Final Drainage Report

McClintock Station Filing No. 1A (Vollmer Road RV Storage)

PROPOSED DRAINAGE MAP
 VOLLMER RV STORAGE
 JOB NO. 25251.00
 01/15/2024
 SHEET 1 OF 1

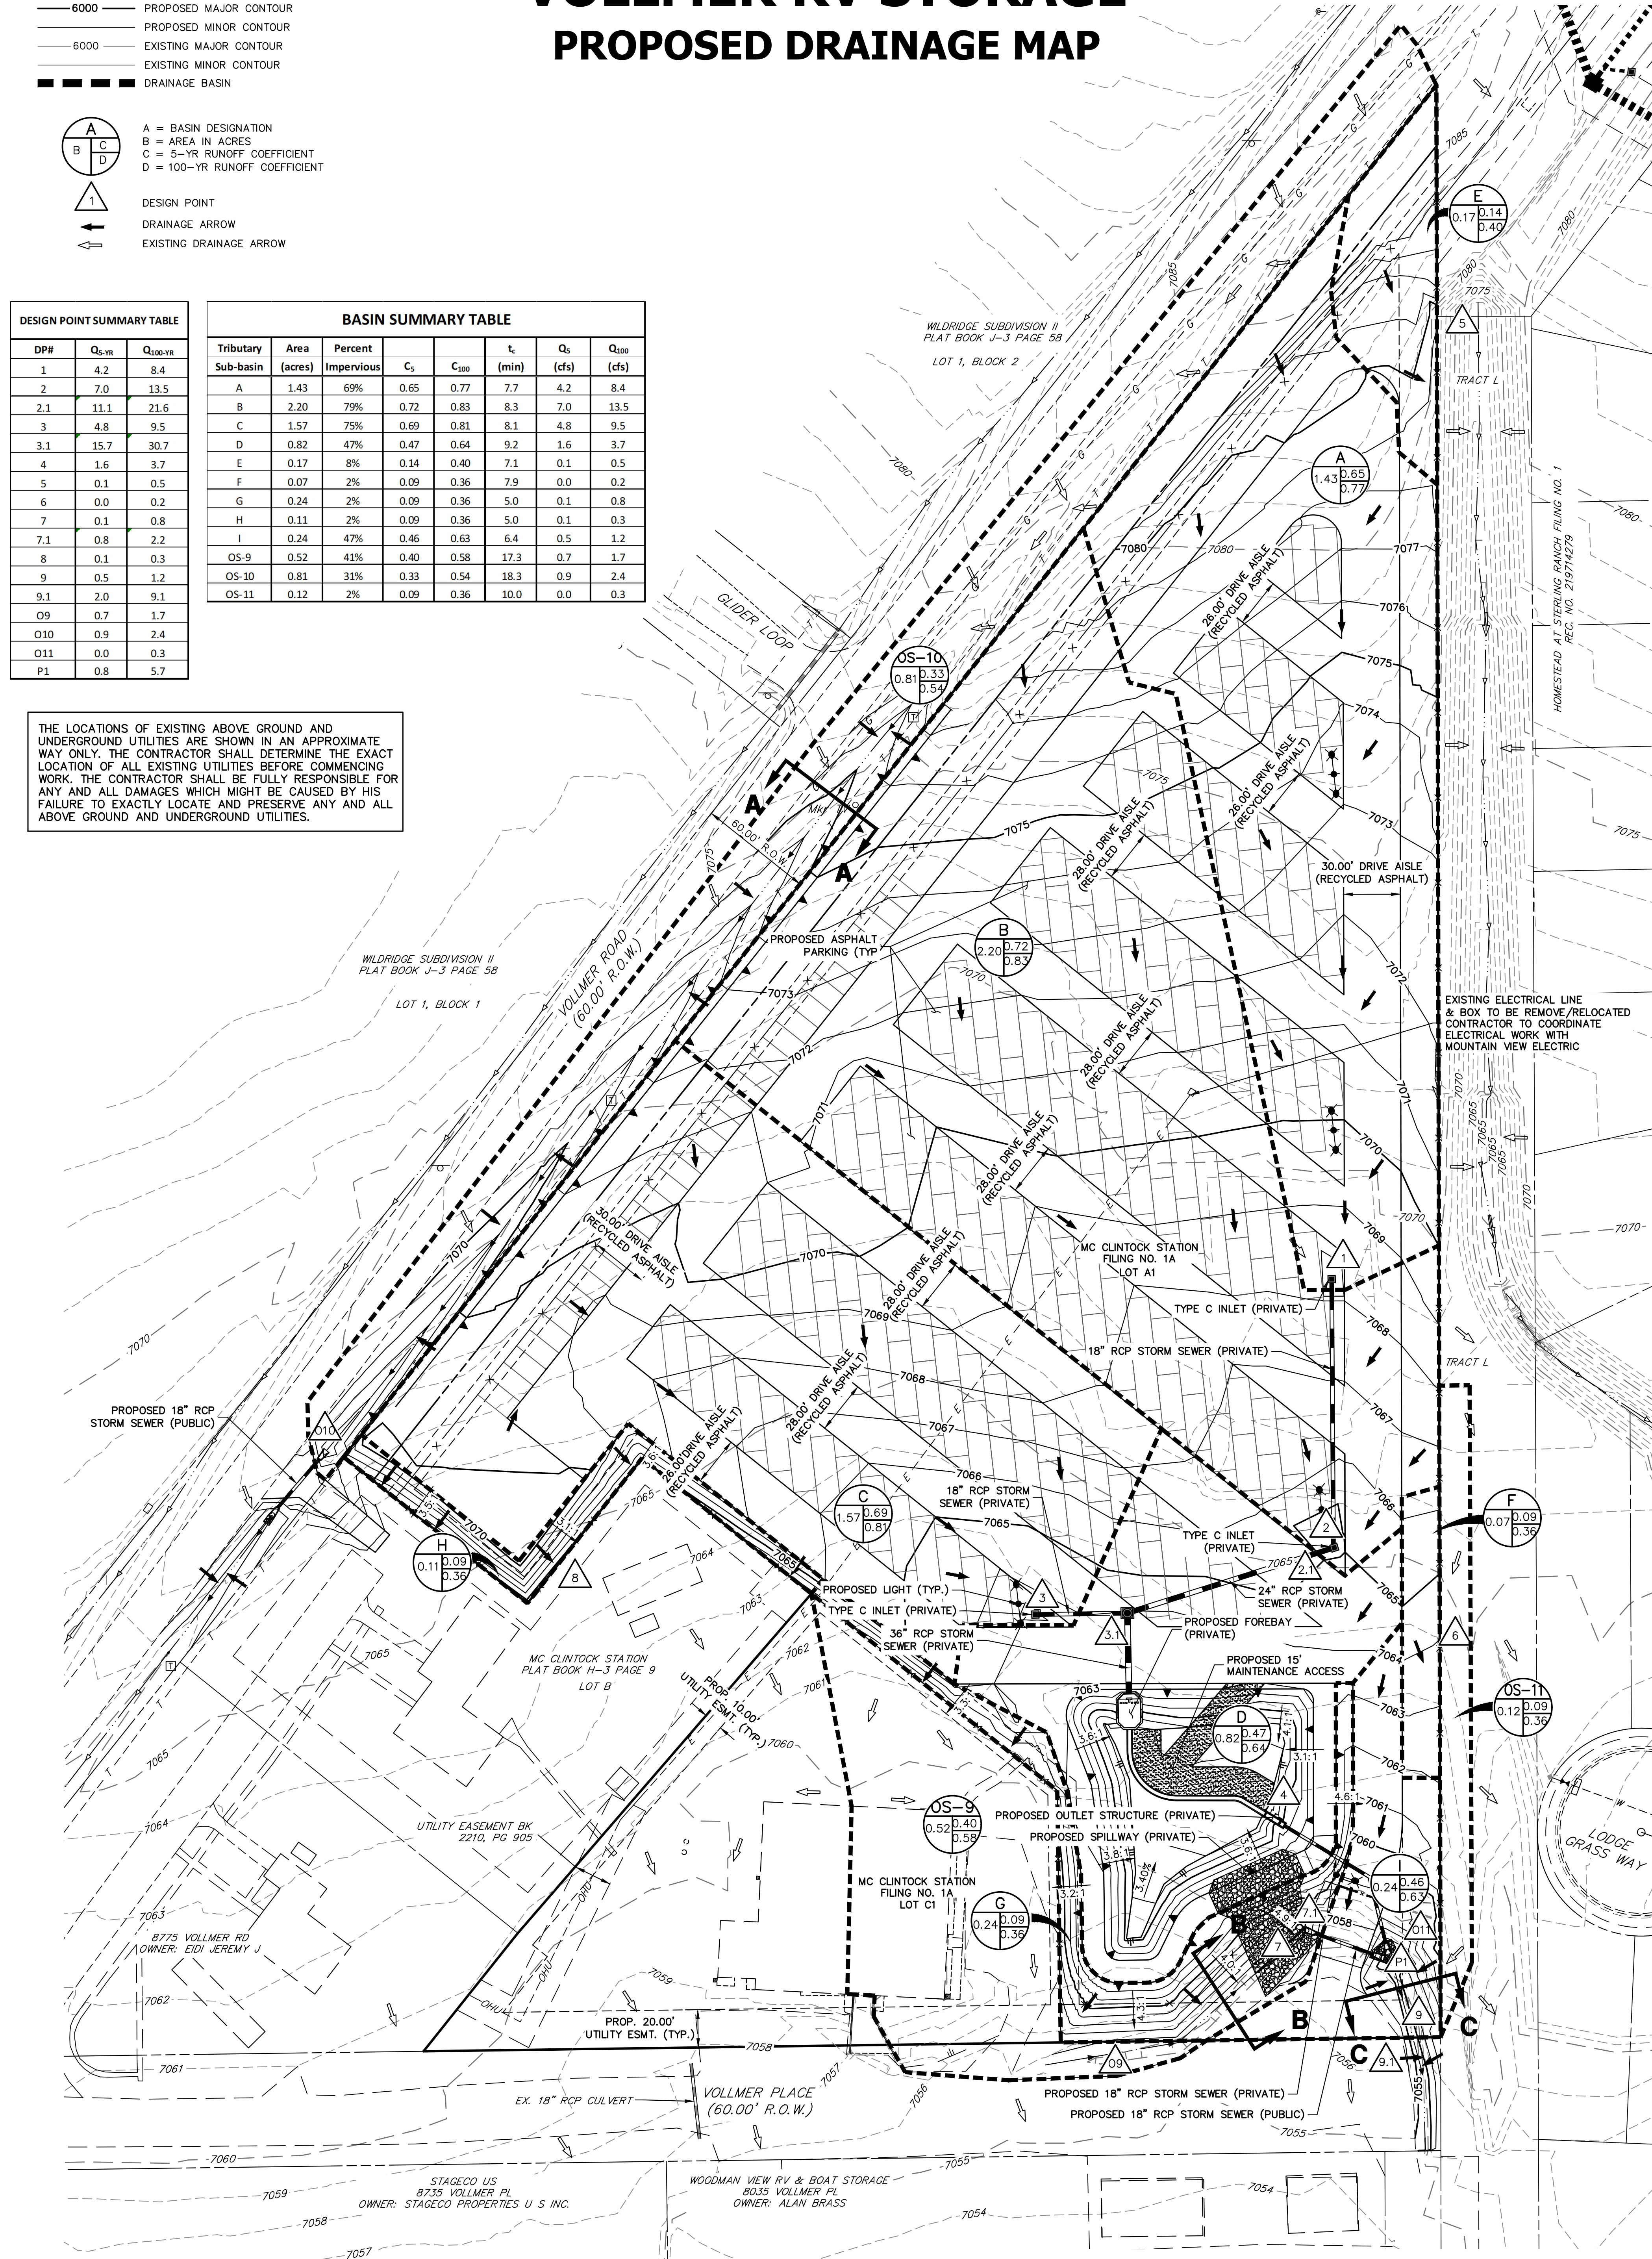
This needs to include flow from DP O11 & DP 7.1. It appears 100 year will be more than existing.

Basin flows still need to be combined with pond release rates. It appears at that point, flows exiting site (DP9.1) may be more than existing. Please revise statement accordingly.

DP O11 should include Basin F/DP 6, as this flow enters Basin OS-11, which then flows back onsite. Please update routing to account for this.

This DP should also include DP P1, the pond release rate. DP is culmination of all flow exiting site.

JR Response: DP9.1 does include this flow. Revised wording. See the comments on the SF-3 form for calculation.

JR Response: DP9.1 does include flow from pond release rate. See the comments on the SF-3 form for calculation. Flows exiting the site are less than the proposed condition.

JR Response:
 This DP does include DP1, the pond release rate. See below for calculations as well as the provided spreadsheet.
 DP7.1 C*A = 0.23, DPO11.1 C*A = 0.02, DP9 C*A = 0.11
 Equals DP9.1 C*A = 0.35 (rounding difference, see spreadsheet provided)
 DP9.1 flows use that C*A value to $Q_5=1.2$ cfs, adding the DP P1 ($Q_5=0.8$ cfs) to flow
 DP9.1 $Q_5=1.2$ cfs + 0.8 cfs = 2.0 cfs
 DP9.1 therefore is the culmination of all flow exiting site

JR Response:
 Per reviewer request, created DPO11.1 which accounts for flow entering back onsite from Basin F and OS11. DPO11.1 is then routed to DP9.1. See provided spreadsheet and comment to the right.
